From:
To: [DCAdmin](#); [RichardA Gilbert](#)
Subject: Submission to the public consultation for Planning Application ref 2021/94552 - Impact on neighbouring Tanner Wood and adjacent related habitats
Date: 08 March 2022 19:19:13
Attachments: [Development proposal effects on Tanner Wood and wildlife habitats 07_03_22.pdf](#)
Importance: High

As detailed in the report, once again, local and national planning protocols are breached in the application. Specifically, the National Planning Policy Framework 2021, Local Plan Policy, LP30 & LP33, and your own Kirklees Housebuilders Design Guide SPD, sections 6.7, 6.9 & 7.39.

Effects on Tanner Wood and Wildlife Habitats

BARNESLEY ROAD : DENBY DALE | SITE LAYOUT

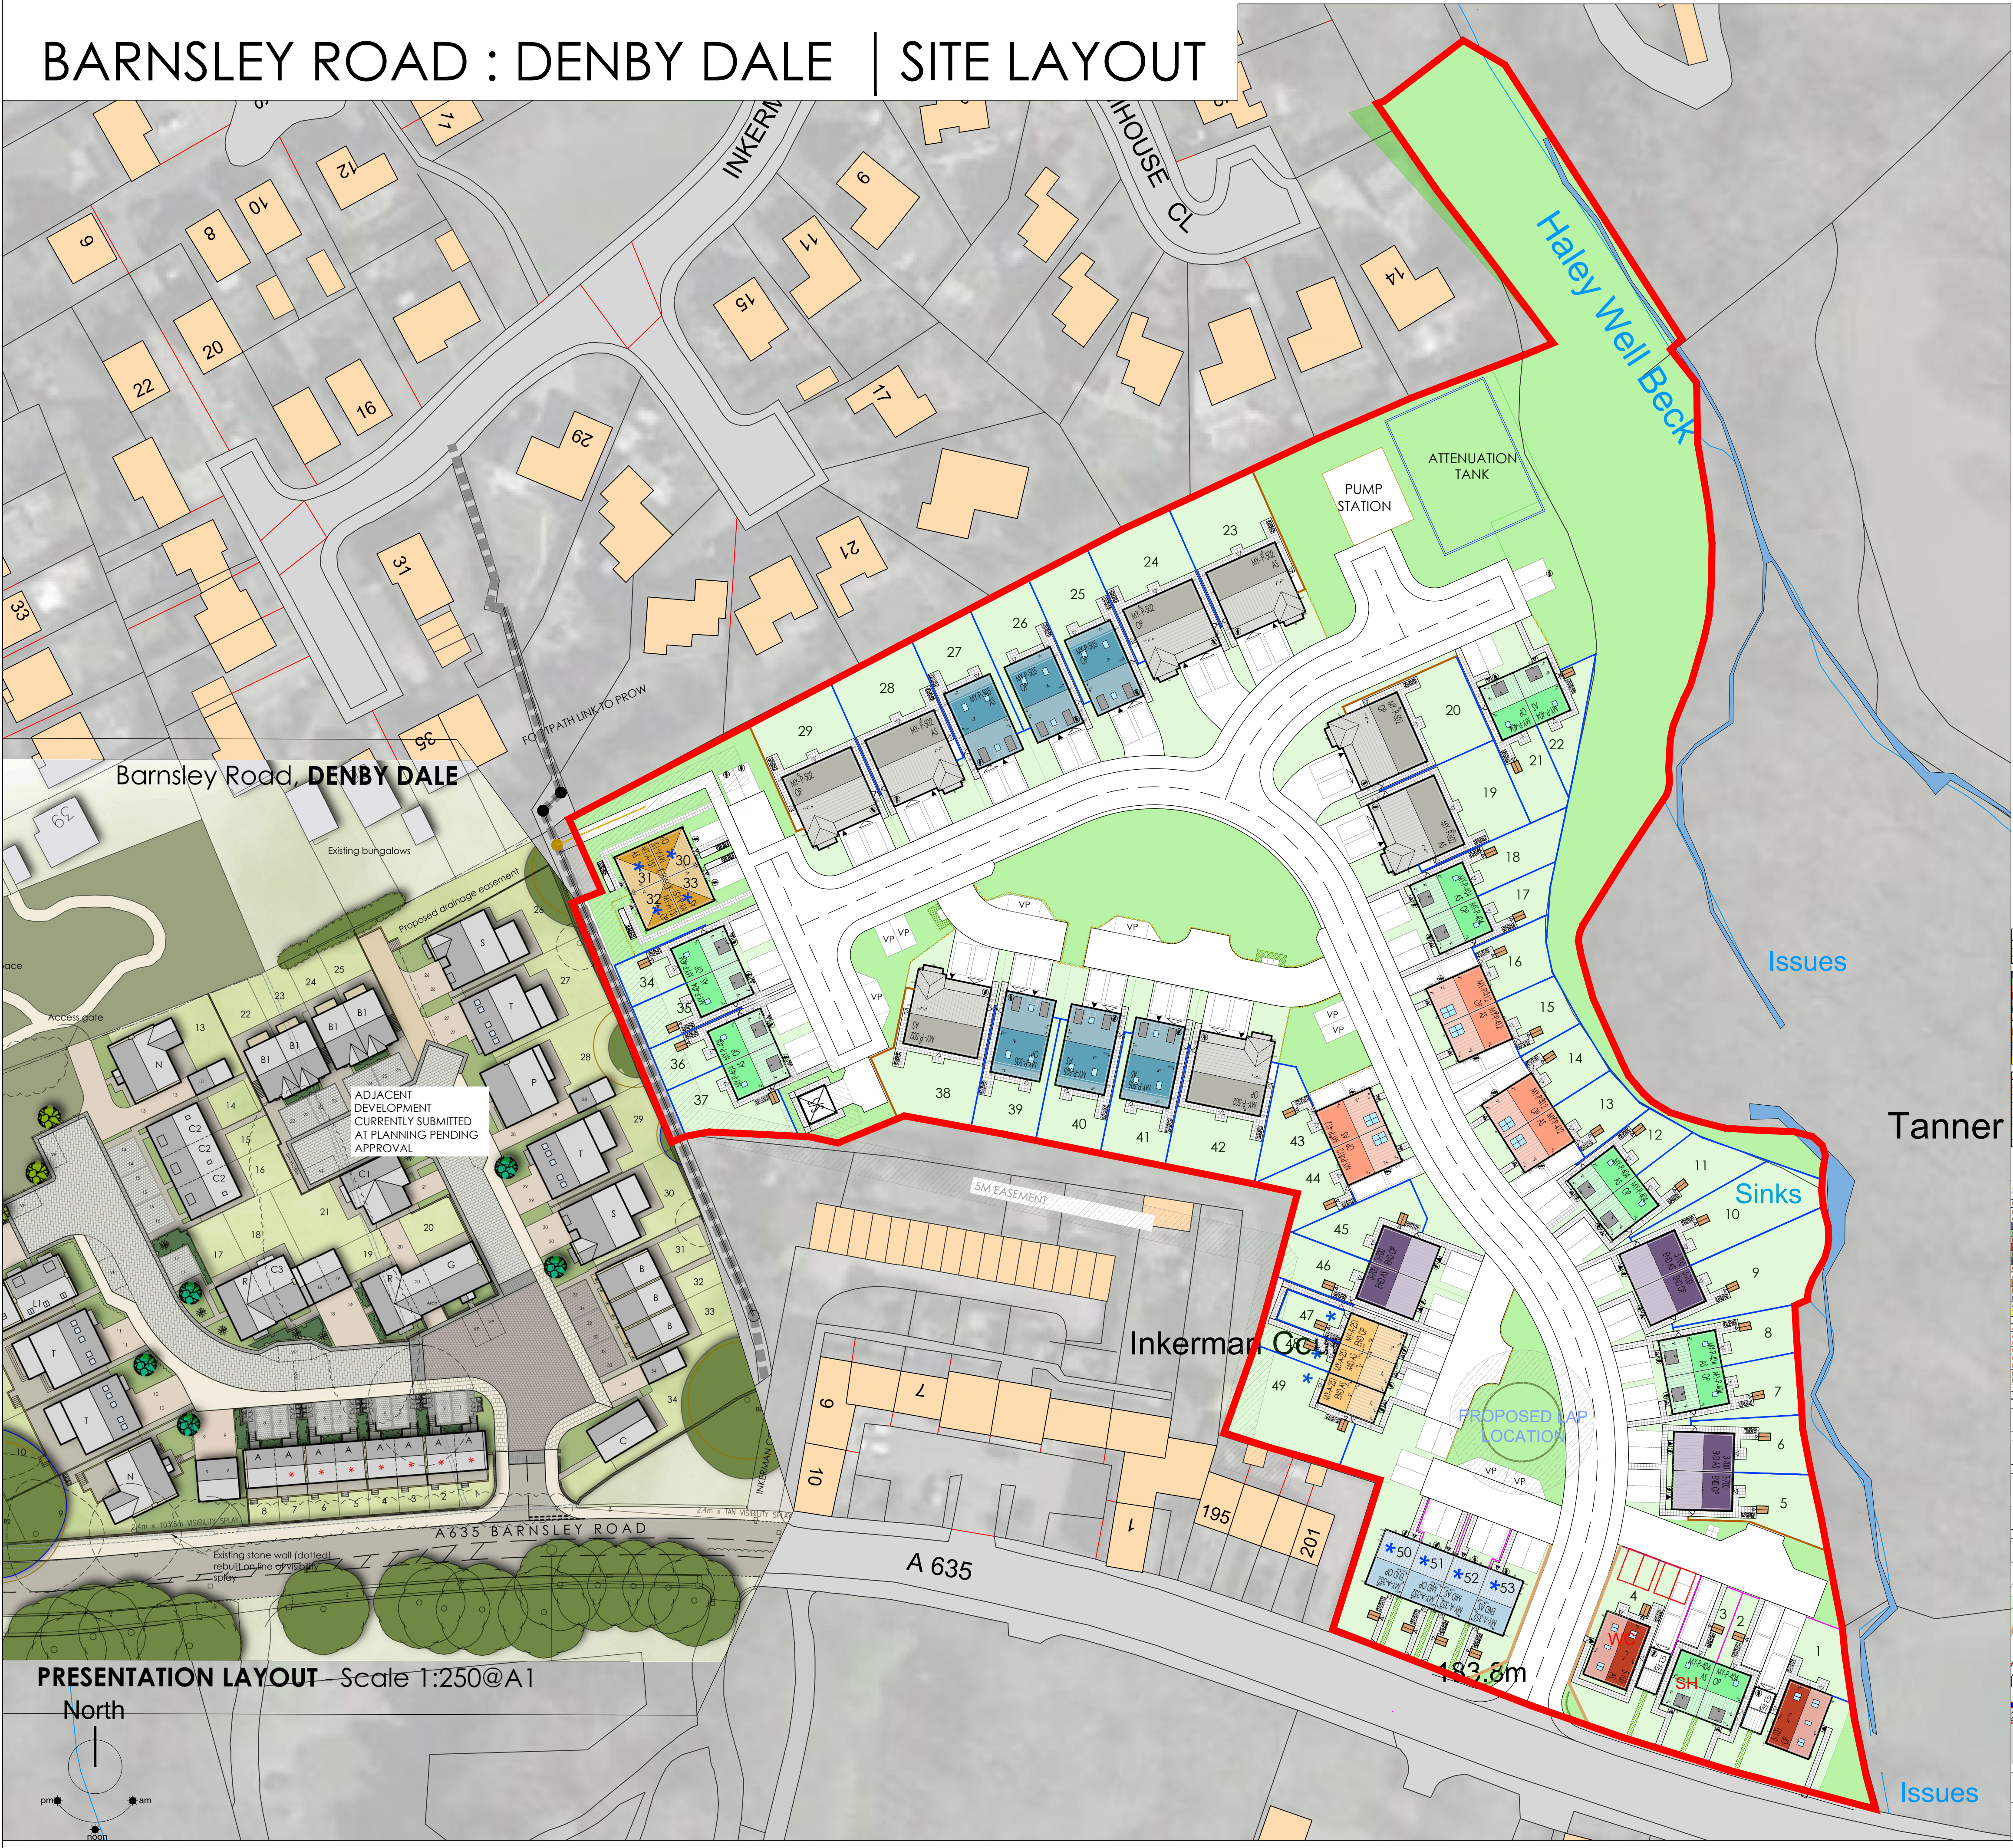
In addition, the proposed retaining wall to the rear of Plots 5 to 10 is right on the boundary with Tanner Wood. It would be impossible to build this structure without damage to the woodland habitat, and risk of contamination to the watercourse running alongside.

To avoid these significant issues, the layout will need to be reviewed and amended, moving the increased ground levels, and retaining wall, away from the RPA's of all of the trees in the table above. This will affect Plots from 7 to 13.

The proposal layout shows houses with gardens right up to the boundary of Tanner Wood; specifically houses 5, 6, 7, 8, 9, and 10. In addition to the unacceptable proximity to the woodland habitat, these properties are extremely close to the watercourse of Hayley Well Beck, which runs North into the River Dearne.

The separation distance from the proposed retaining wall and garden fencing to the watercourse is in some cases less than 1m, and at most under 6m.

The discharge of the surface water easement shows an area extending outside the boundary of the development site, onto private property (over the red line between G10 & G11 in the below extract taken from the site layout/landscaping plan).

Permission for this has not been sought from the landowner. Therefore the easement must be moved so as to wholly lie within the development site.
